Prepared for:
Health Infrastructure NSW

Date:
25 October 2021

Submissions and Amendment Report (SSD-10349252)

Paediatric Services Building The Children's Hospital at Westmead

Scale	Date	
1 : 500@A1	16/11/20	
Drawn By	Checked By	Revision
SM	AF	A
Project No	19038	
Drawing No	CHW-AR-DG-PSB-SSD016

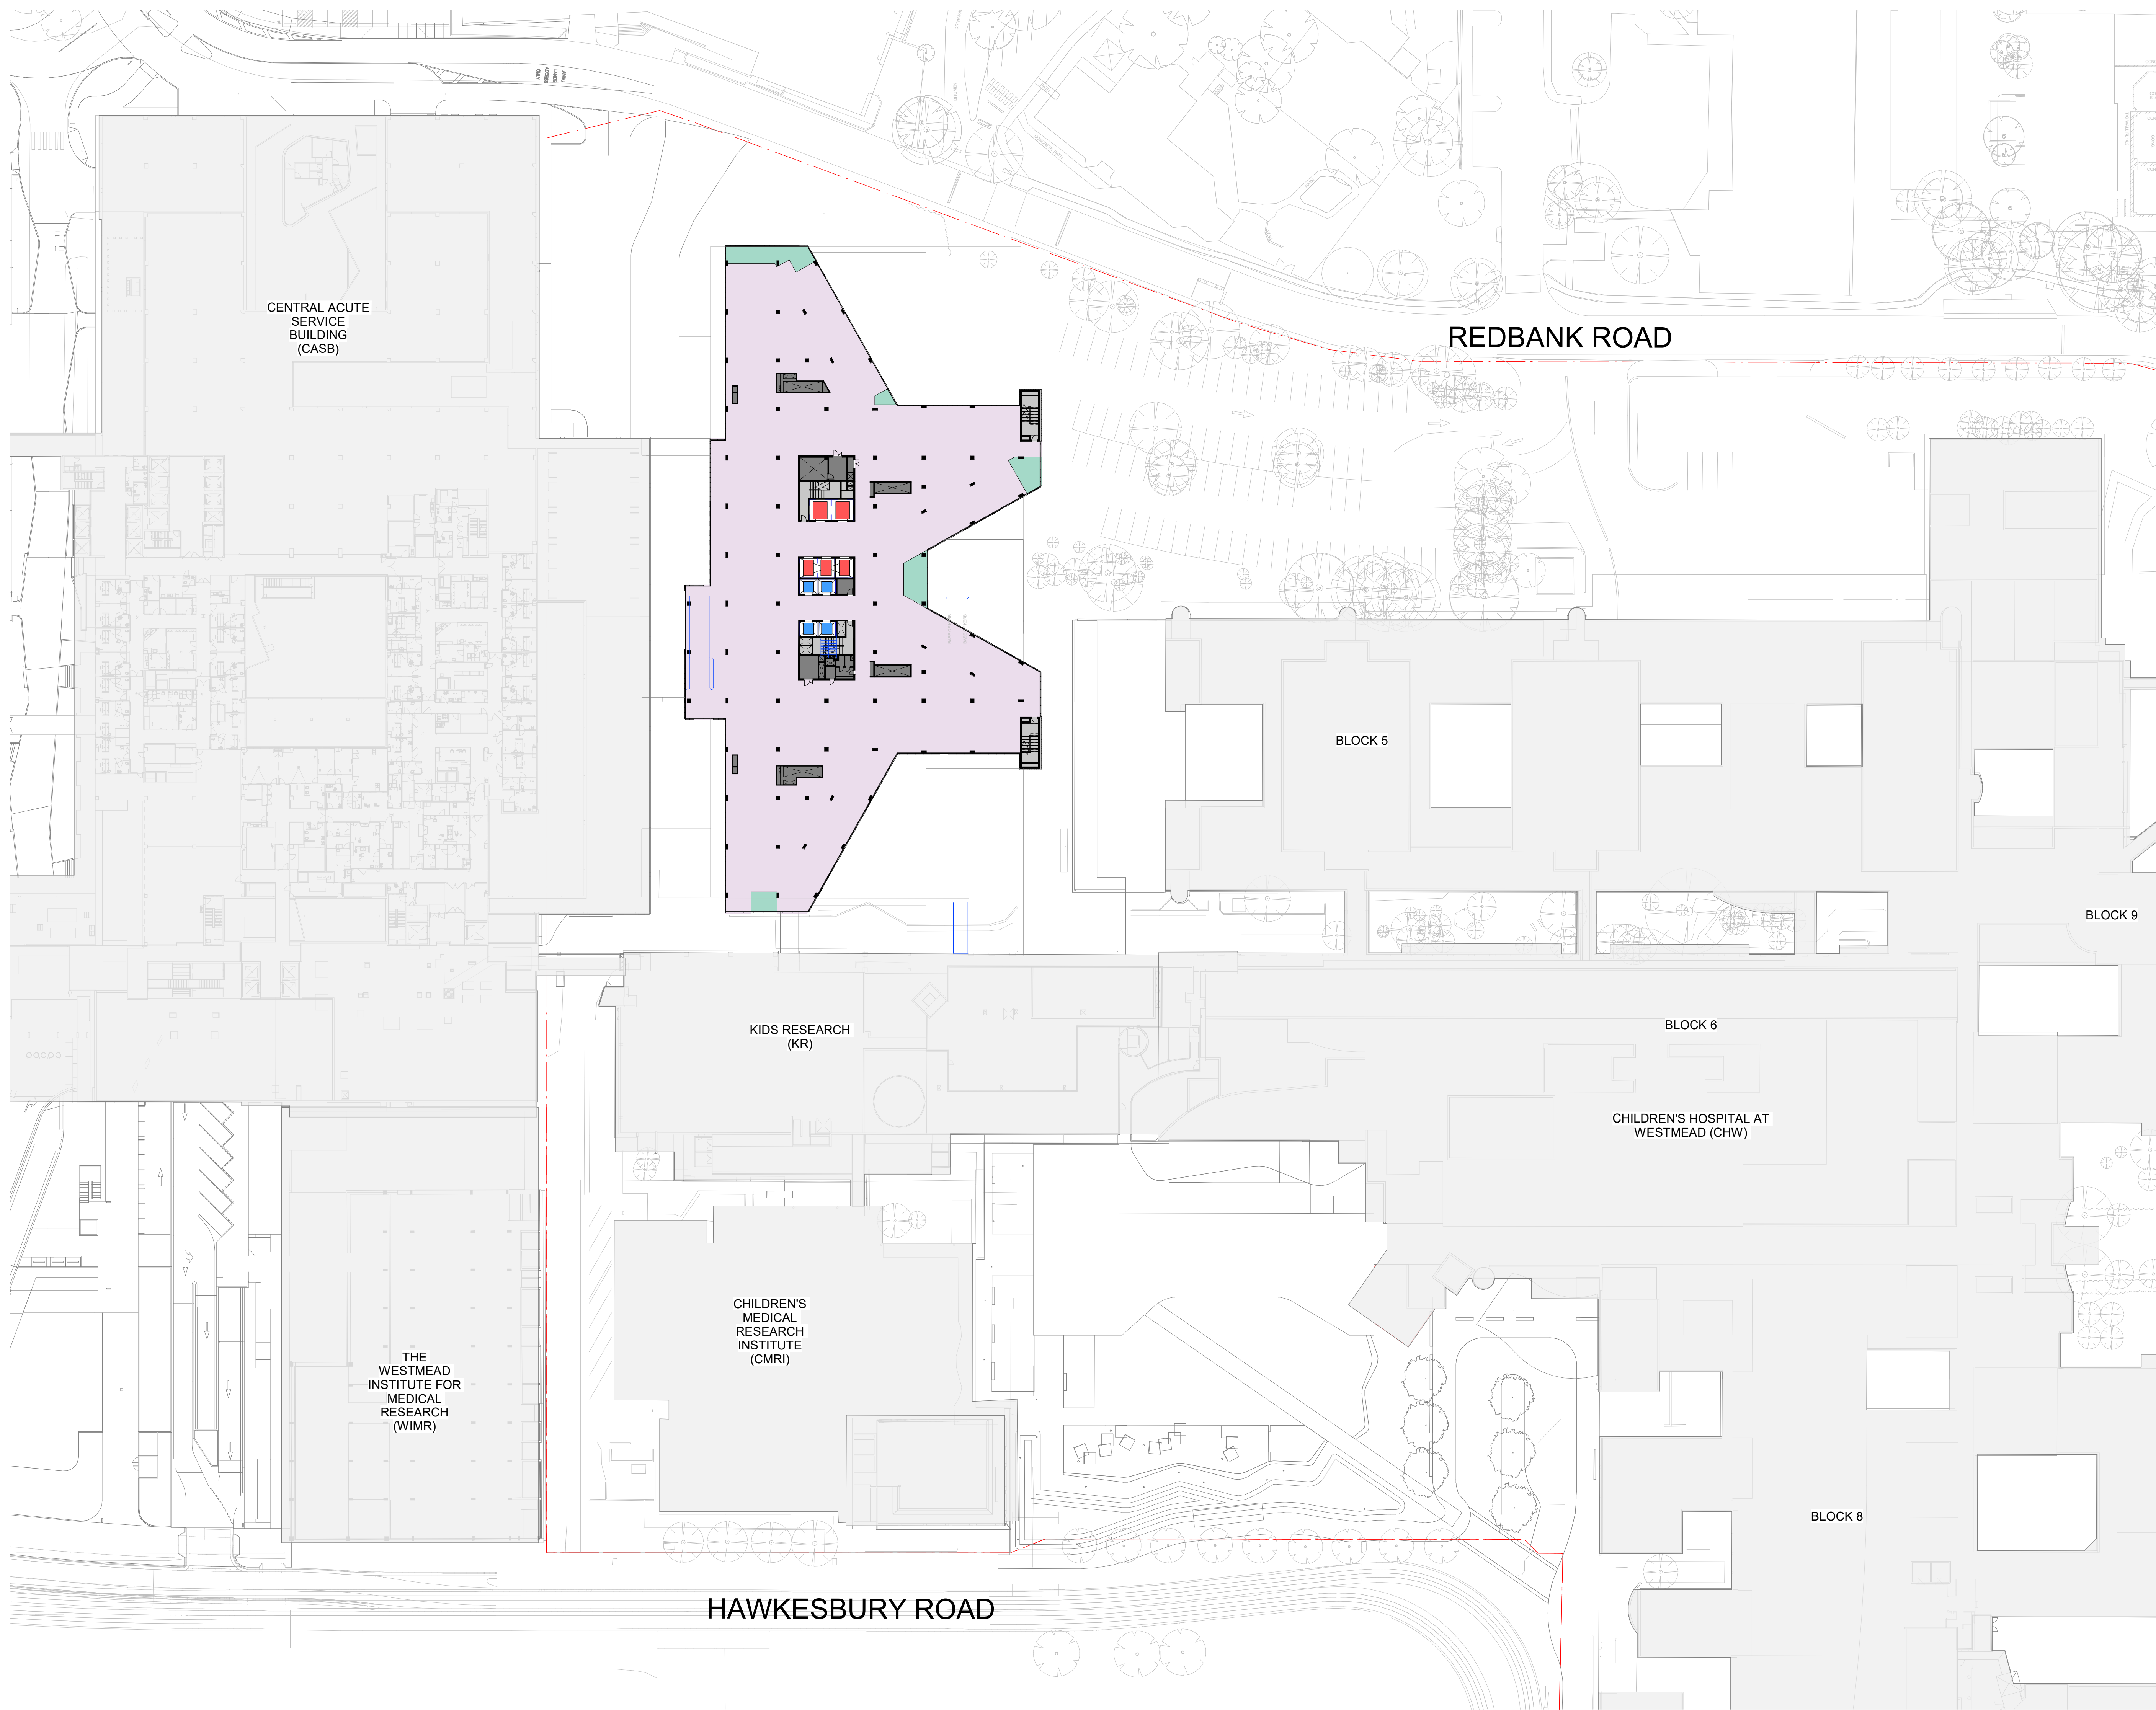
The proposed building height, site layout and design scheme remain generally unchanged from what was originally proposed and exhibited. However, the amended proposed development seeks consent for a minor change to the building footprint and subsequent increase in gross floor area (GFA), as a result of squaring out the northern and southern wings of Level 07 to match the squared-out floor plan and shape of Level 01 to Level 06. Refer to **Figure 1** and **Figure 2**. As noted previously the driver of this design change was to meet clinical requirements, in this instance for critical overnight beds.

Figure 2 Amended Level 07 Proposed Plan.
The northern and southern wings have been squared out.
Source: Billard Leece Partnership Architects

This has resulted in changes to the GFA at Level 07, increasing by 122 sqm from 4,282 sqm to 4404 sqm. It is noted that there have been further changes to the GFA at other levels of the PSB; however, these have not resulted in any change to the building footprint. Refer to Table 5 for a summary of GFA changes by level.
